Application Ref:	2025/0915			 Ribble Valley Borough Council www.ribblevalley.gov.uk				
Date Inspected:	22/01/2026	Site Notice:	N/A					
Officer:	EP							
DELEGATED ITEM FILE REPORT:					REFUSAL

Development Description:	Proposed alteration to existing stone wall boundary treatment to include an increase in height through the introduction of stone columns and fence panels.
Site Address/Location:	7 Shays Drive Clitheroe BB7 1LL.

Drawing No; P102 - 28/01/26

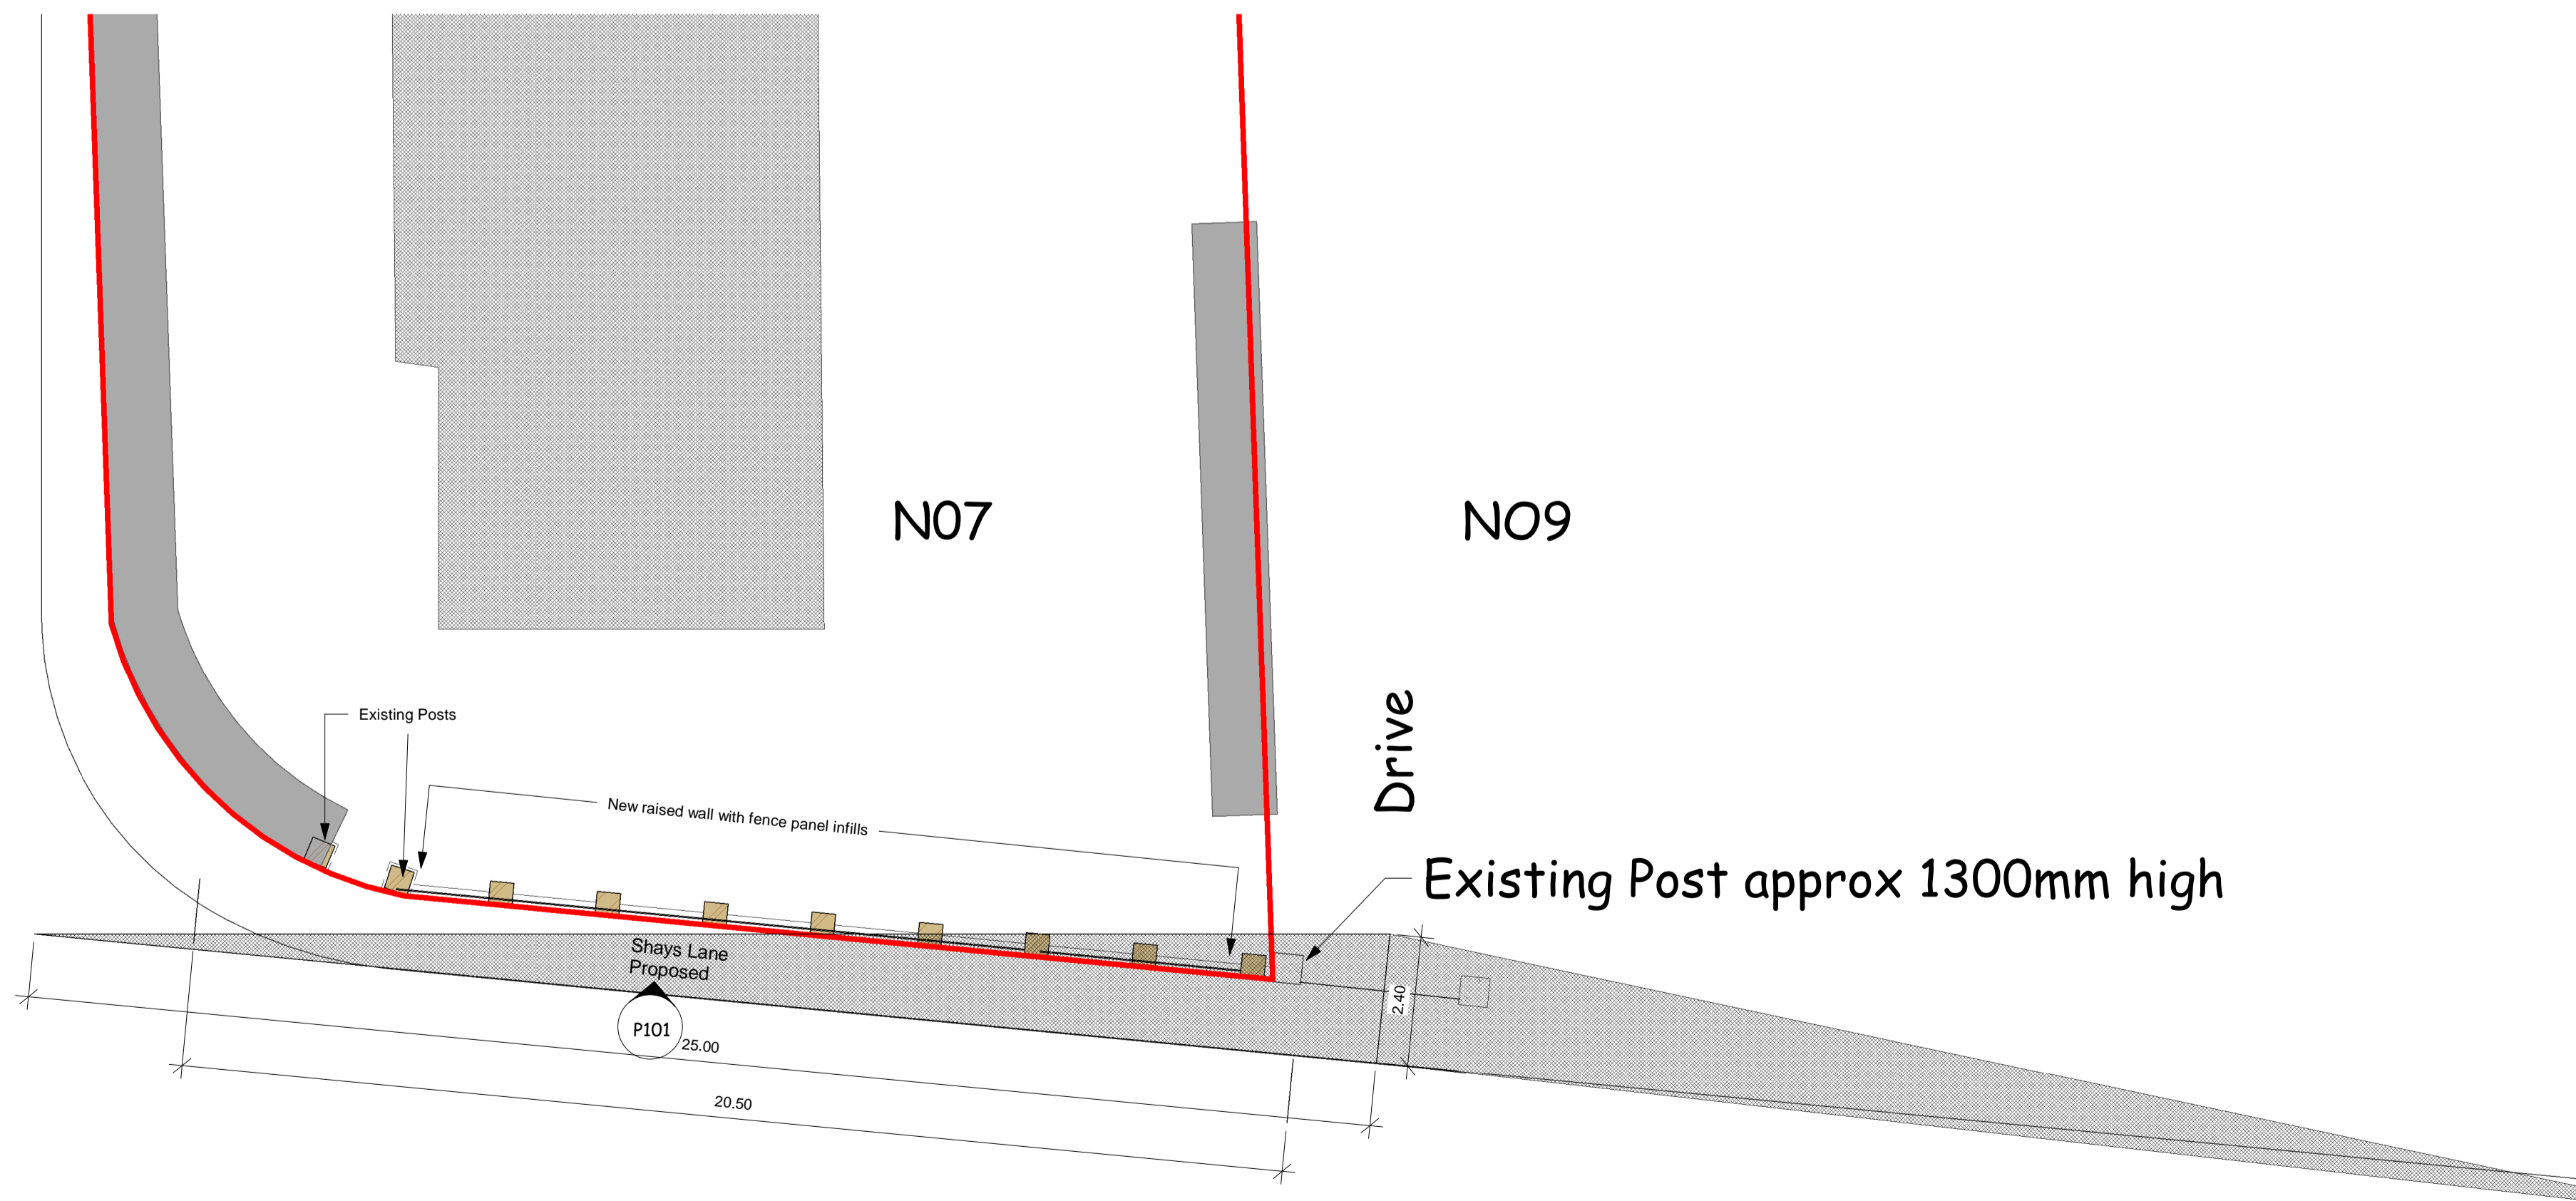
The submitted plan shows that approximately 6.5m of the visibility splay required for the neighbouring property (No. 9 Shays Drive) falls within the proposed fence line, including four of the proposed 1.8m-high pillars. The LHA therefore considers that the proposal would significantly obstruct visibility for vehicles emerging from No. 9. Consequently, the proposal would result in the use of an access that lacks adequate visibility, creating a highway safety concern.
